**PROJECT# 1010273**

**PROJECT NAME:** NORTH ALBUQUERQUE ACRES Unit(s) 3

DATE: January 23, 2015  
TO: Jack Cloud, DRB Chair  
FROM: Catalina Lehner, Senior Planner   
RE: Project #1010273, La Cueva Assisted Living Facility  
Site Development Plan for Building Permit

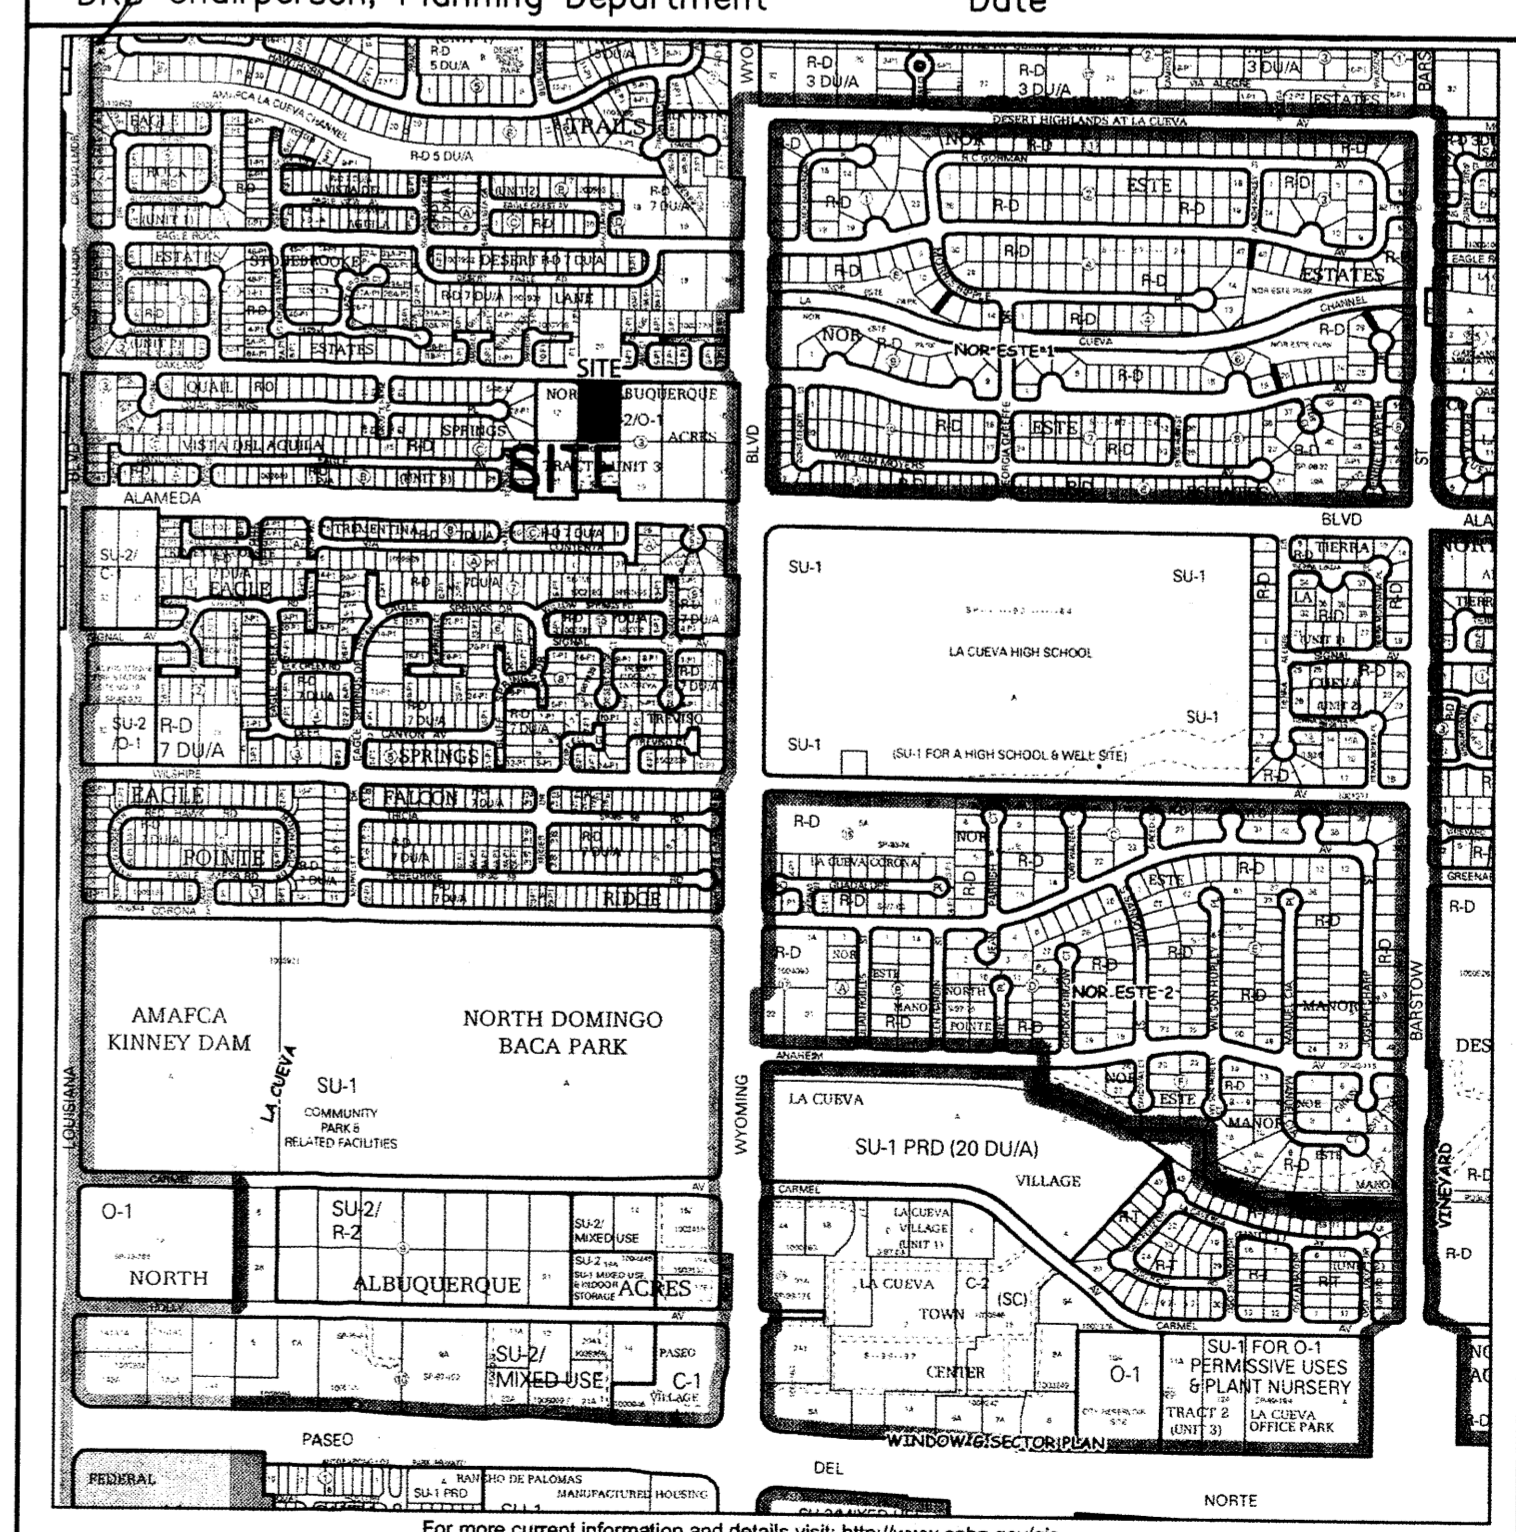
*First, it would be helpful to not change the scale of the site development plans. Staff requests that the scale be returned to 1/16. The new 1:20 is smaller and makes the drawings harder to read. I don't see a compelling reason to make them smaller. Also, the entire Zone Atlas page doesn't really need to be shown on A001. An excerpt, or smaller version, would suffice if more space is needed.*

Wheel stops need to be shown. Without wheel stops, the sidewalk goes down to 6 feet clear. That is less than the Zoning Code minimum requirement of 8 feet clear when a building façade faces a parking area (14-16-3-1(H)(4), and contrary to the intent of the LCSDP. The LCSDP requires 15 feet of sidewalk in front of the entrance façade. Though this was interpreted by the ZEO to mean only the entrance portion, the intent of the LCSDP is that sidewalks be wider than minimum requirements.

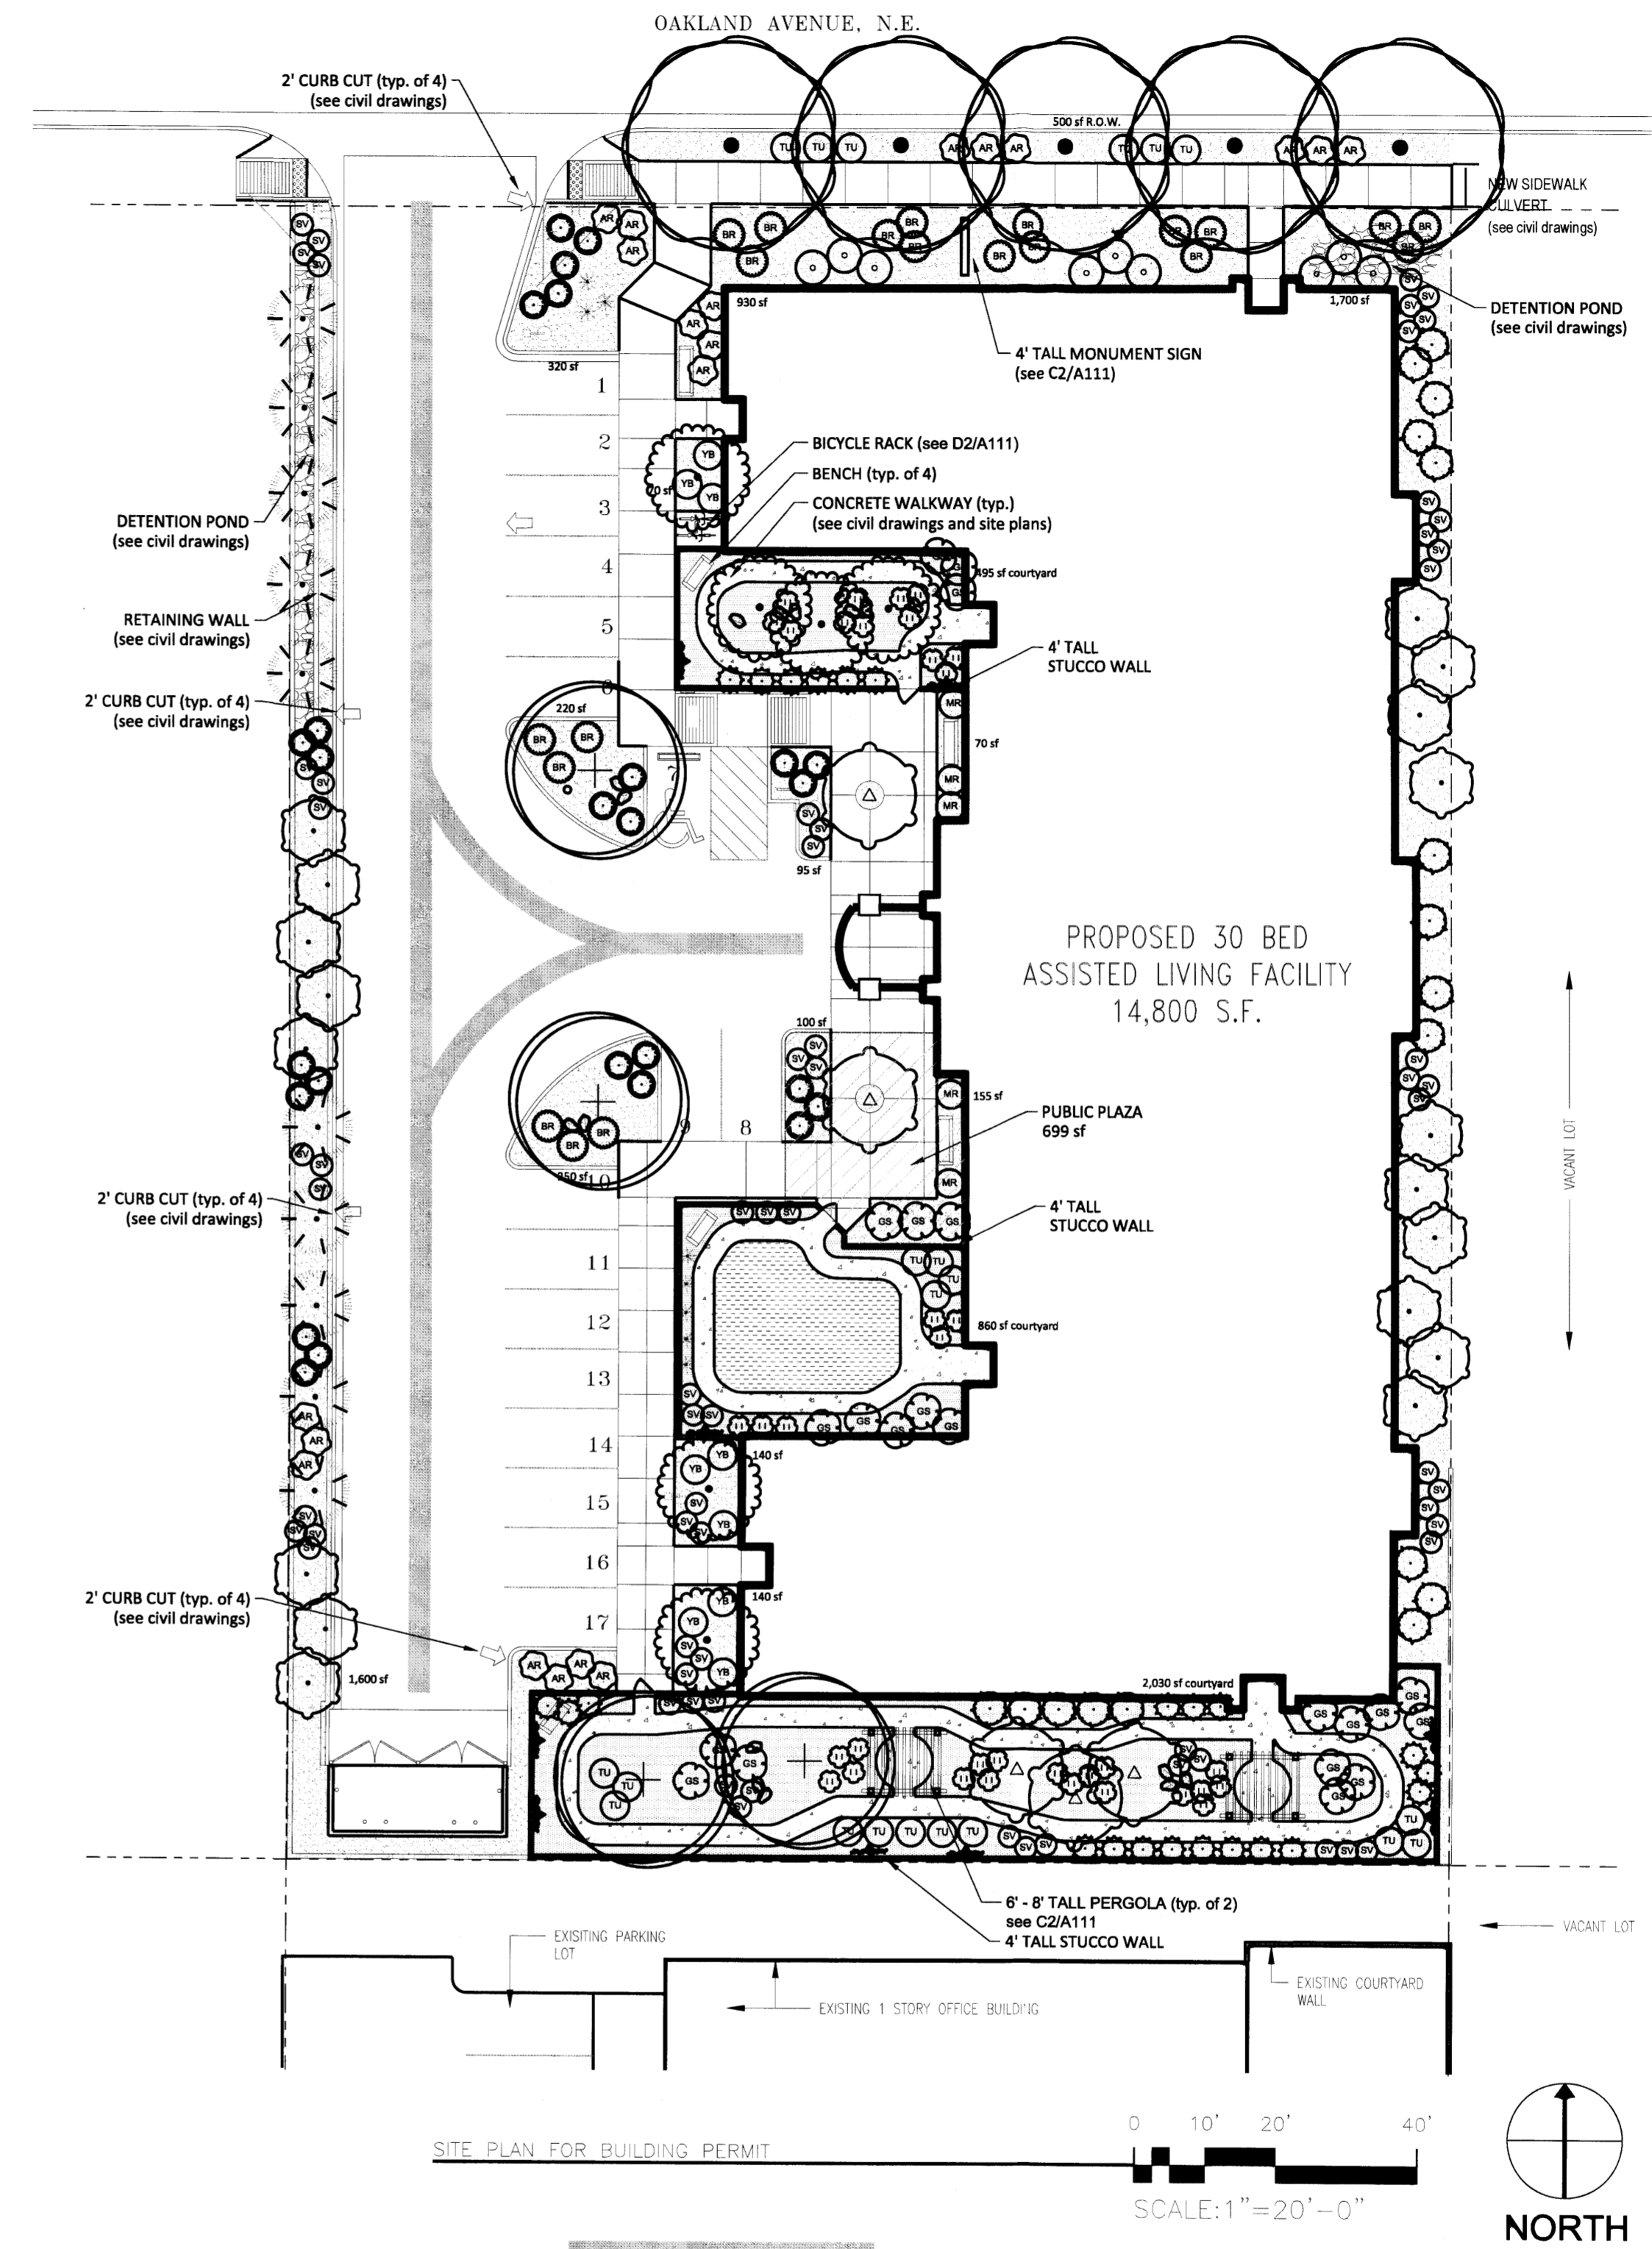
General: Evergreens are required to be at least 10 feet tall at time of planting. Juniper have to be "female only".

7B- though improved, the 75% coverage requirement is not quite met in the eastern and western landscaping beds. Since the emphasis is along Oakland Ave., however, maybe adding more ground cover there would improve the overall landscaping in lieu of adding more ground cover to the side buffers.

7D- note that there are 4 curb notches on the LS plan and 2 on the G&D plan (see Condition #11, below).

CONCEPTUAL GRADING
 30-Bed Assisted Living Home
 Lot 13, Tract 2, Block 3, Unit 3
 North Albuquerque Acres, Albuquerque NM
 C001

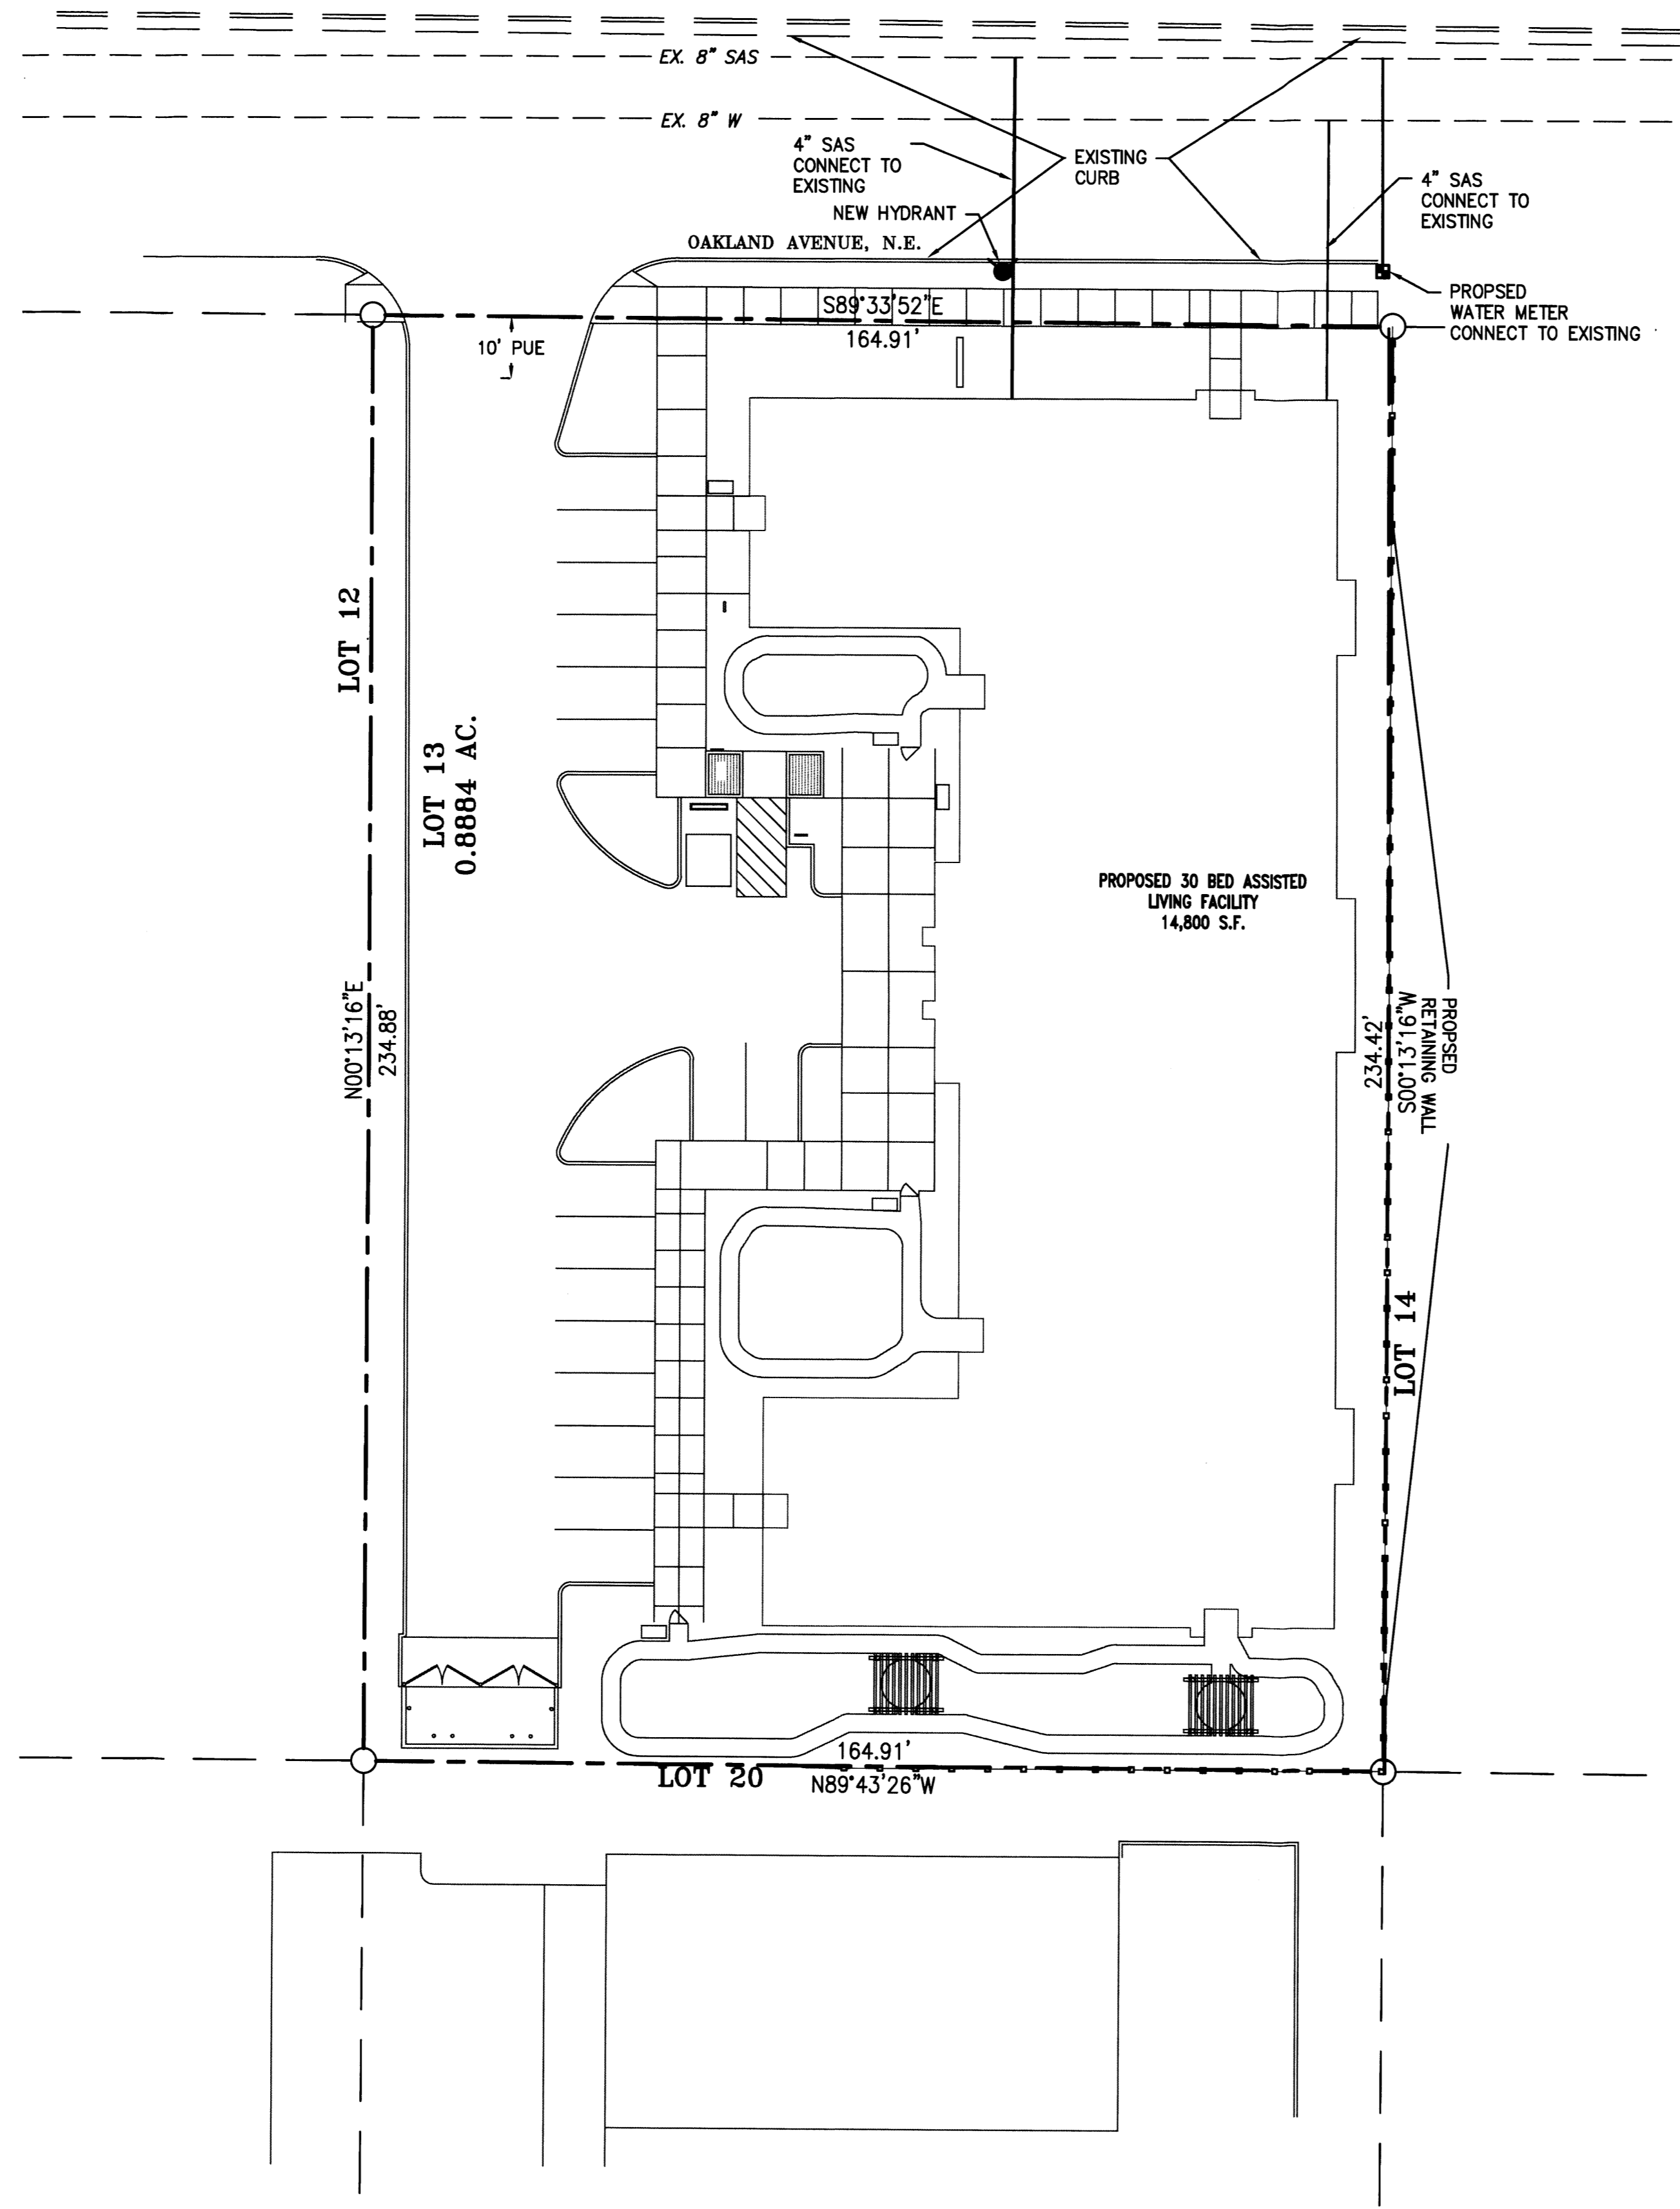
General: The curb notches need to be placed in a meaningful location so water can flow into them. This needs to be checked, because I didn't see any flow arrows.

General: Only 2 curb notches are shown on the G&D Plan, but 4 are shown on the LS plan. The G&D plan needs to match the LS plan and show the 4.

11C- A curb notch detail shall be included.

C2 MONUMENT SIGN
1/2"=1'-0"

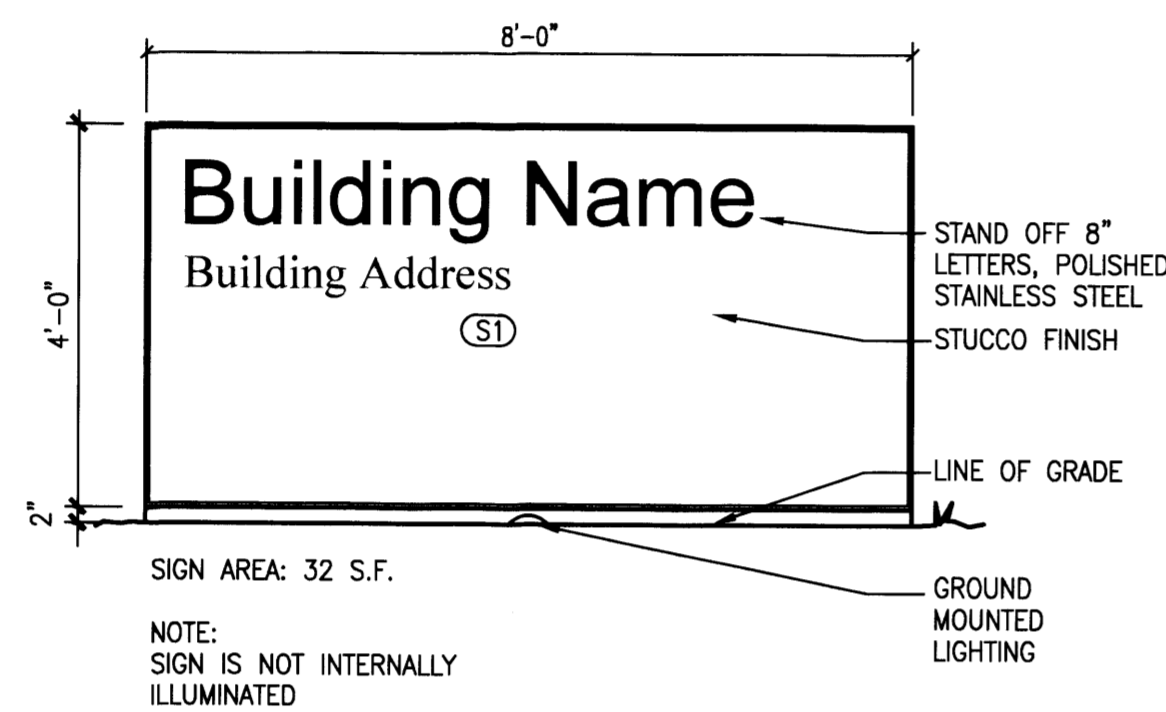
Add a note stating that the sign is not internally illuminated.
